Rezoning Transportation Analysis

Petition Number: 2017-118

Revision Log:

Date	Description
08-16-17	First Review, KLA
11-30-20	Second Review, EL
01-22-21	Third Review, EL
03-30-21	Fourth Review, EL
04-15-21	Fifth Review, EL

DATE: 04/12/21  
FILE: MHP/PL  
DRAWN BY: RST  
REVISED:  
JOB NO: \_\_\_\_\_  
SHEET: **RZ-1**  
OF: \_\_\_\_\_

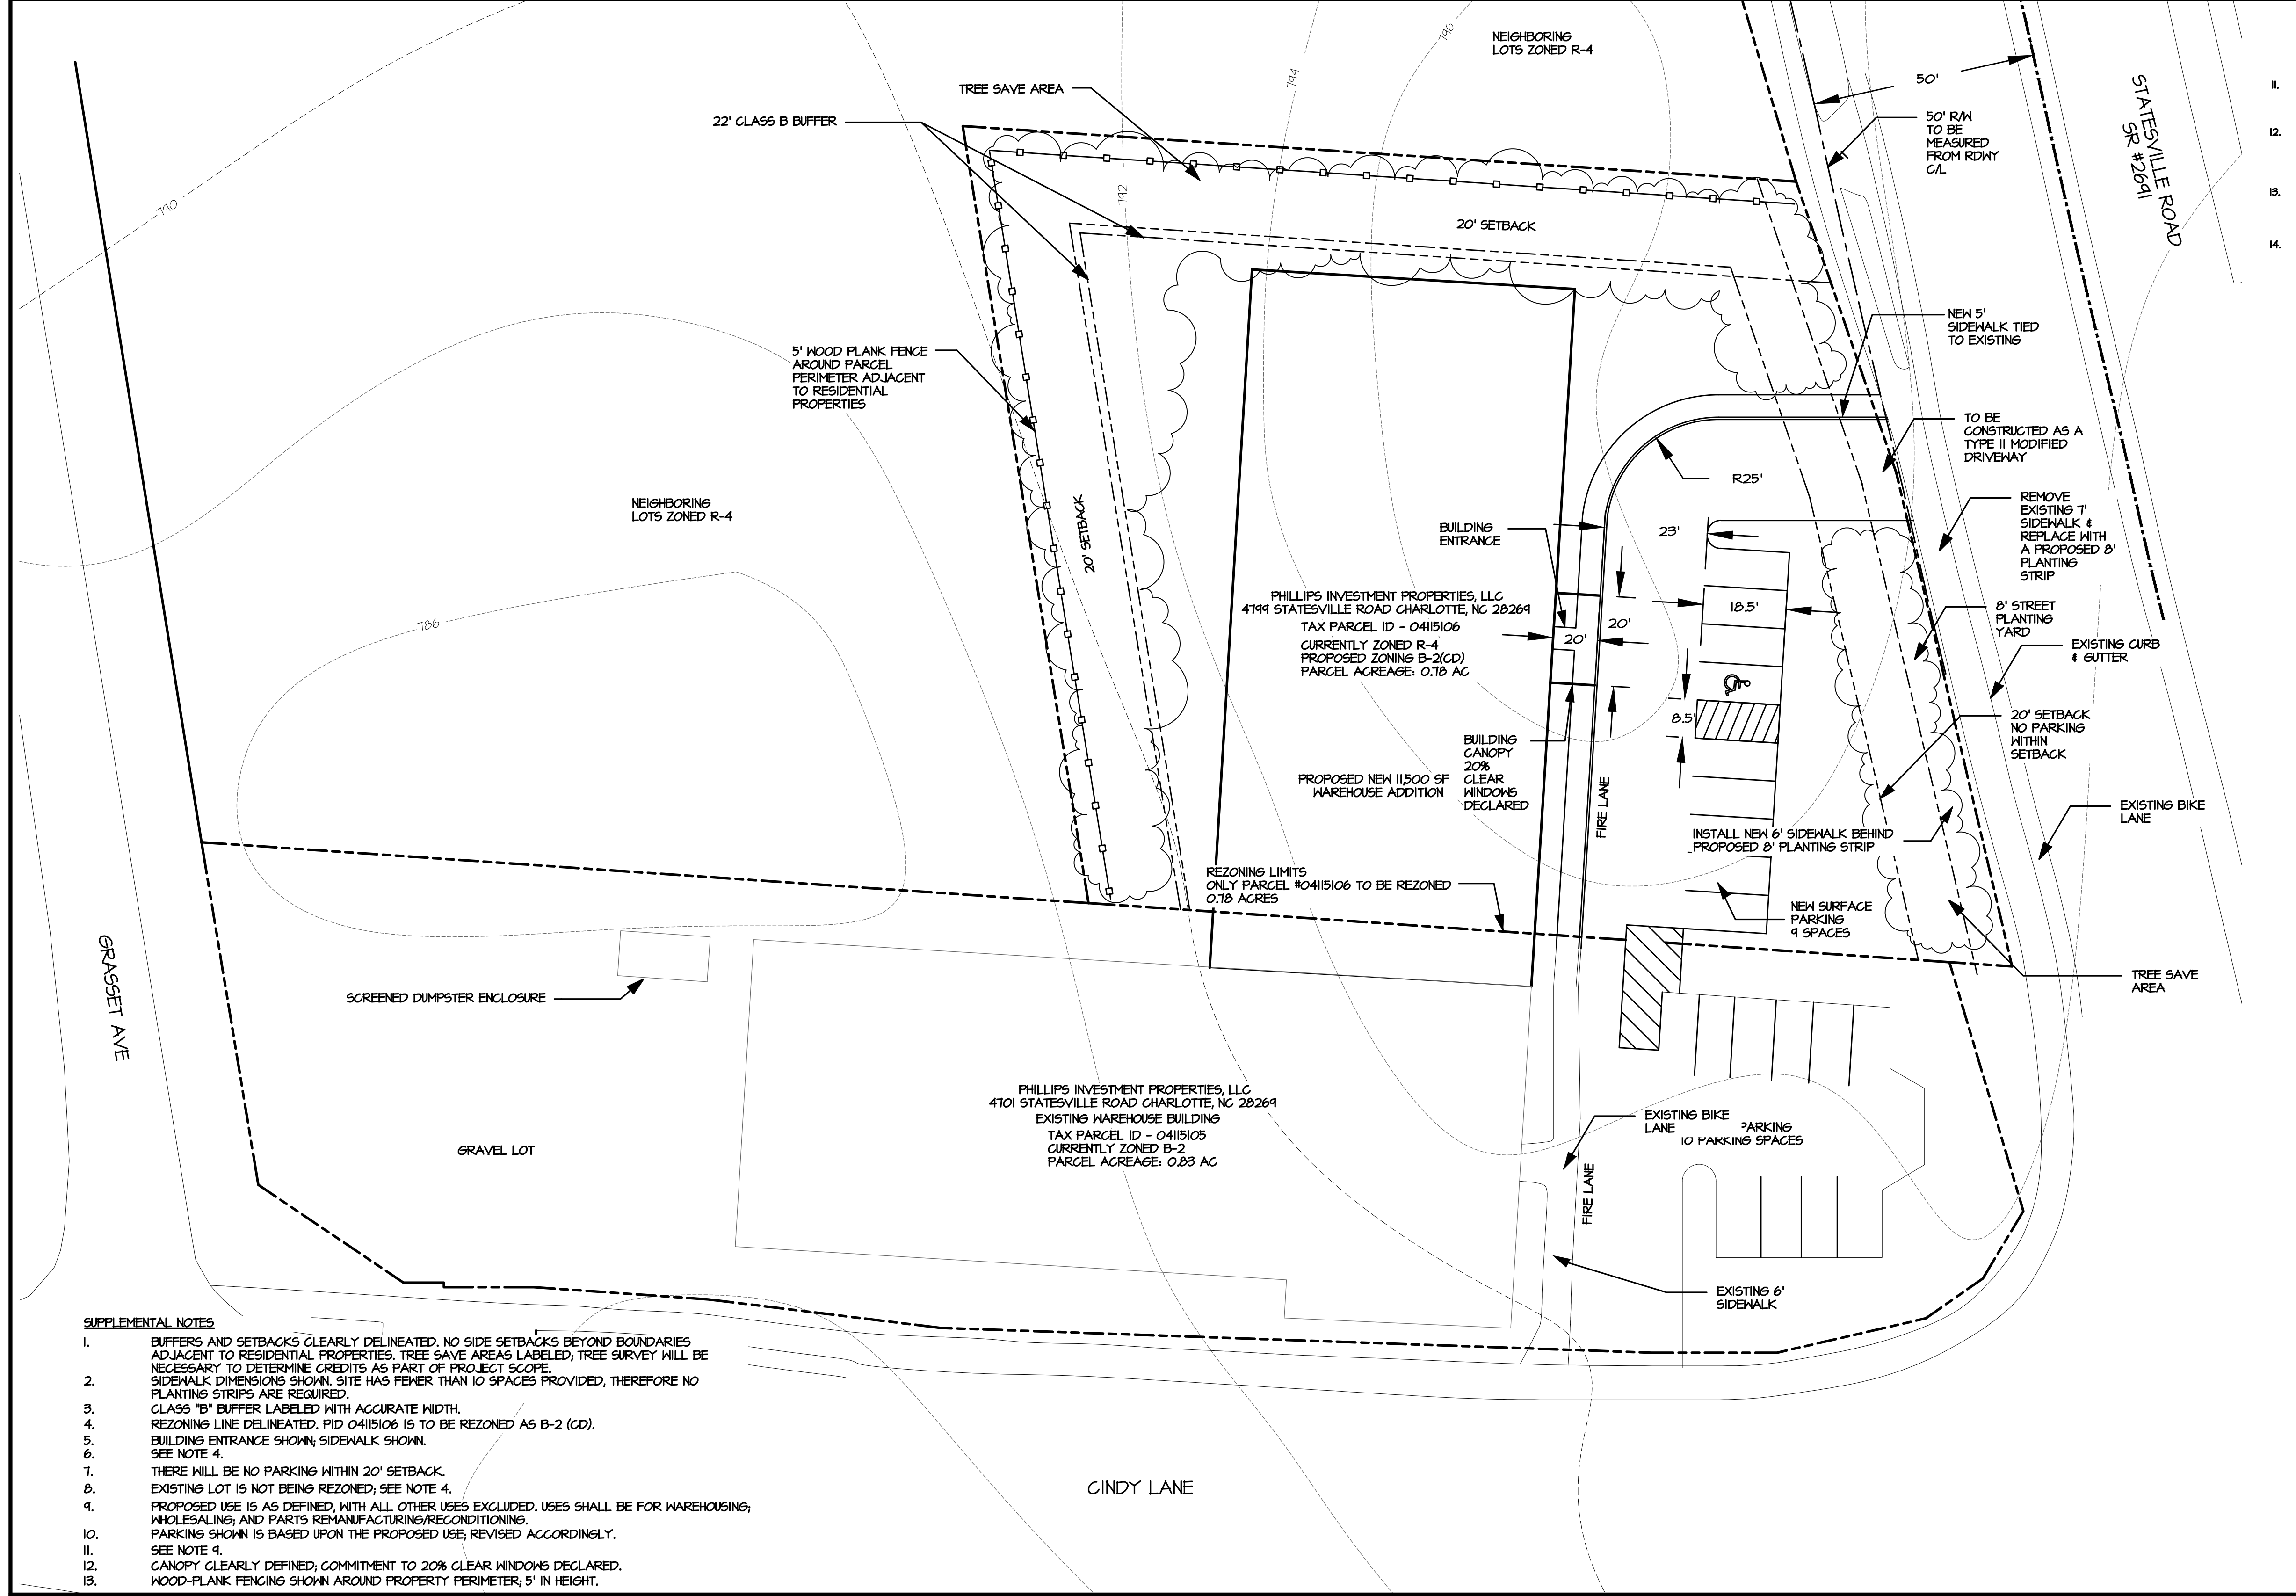
2. ~~**Outstanding Comment (site plan dated 05/11/20)** The petitioner should revise the site plan to show the driveway on Statesville pushed back away from the signalized intersection as far as possible and would need to be reconstructed as a Type II Modified Driveway during permitting. CDOT would like to see closure of Cindy Lane driveway if possible.~~

3. ~~**Outstanding Comment (site plan dated 05/11/20)** If large trees are removed, the petitioner should reconstruct to an 8' planting strip and 6' sidewalk along frontage, as required by Chapter 19 of the City Code. The proposed planting strip must be a minimum of 8' in width. The 6' sidewalk may meander around the existing trees, if contained within a sidewalk utility easement, which is to be placed 2' from the proposed back of sidewalk. The planting strip must be installed between the existing back of curb and proposed sidewalk. Refer to the additional design references provided below.~~

4. ~~Outstanding Comment (site plan dated 05/11/20)~~ Revise the site plan to dimension the proposed right of way dedication from the Statesville Road centerline. Additional design guidance is provided below.

- ~~5. **New Comment (site plan dated 05/11/20)** The petitioner should revise the site plan to add a note specifying dedication and fee simple conveyance of all rights of way to the City before the site's first building certificate of occupancy is issued. CDOT requests right of way set at 2' behind back of sidewalk where feasible.~~
- ~~6. **New Comment (site plan dated 05/11/20)** Add site plan note specifying that all transportation improvements will be approved and constructed before the site's first building certificate of occupancy is issued. The petitioner may phase transportation improvements if said improvements and phasing are explicitly described in site plan notes.~~
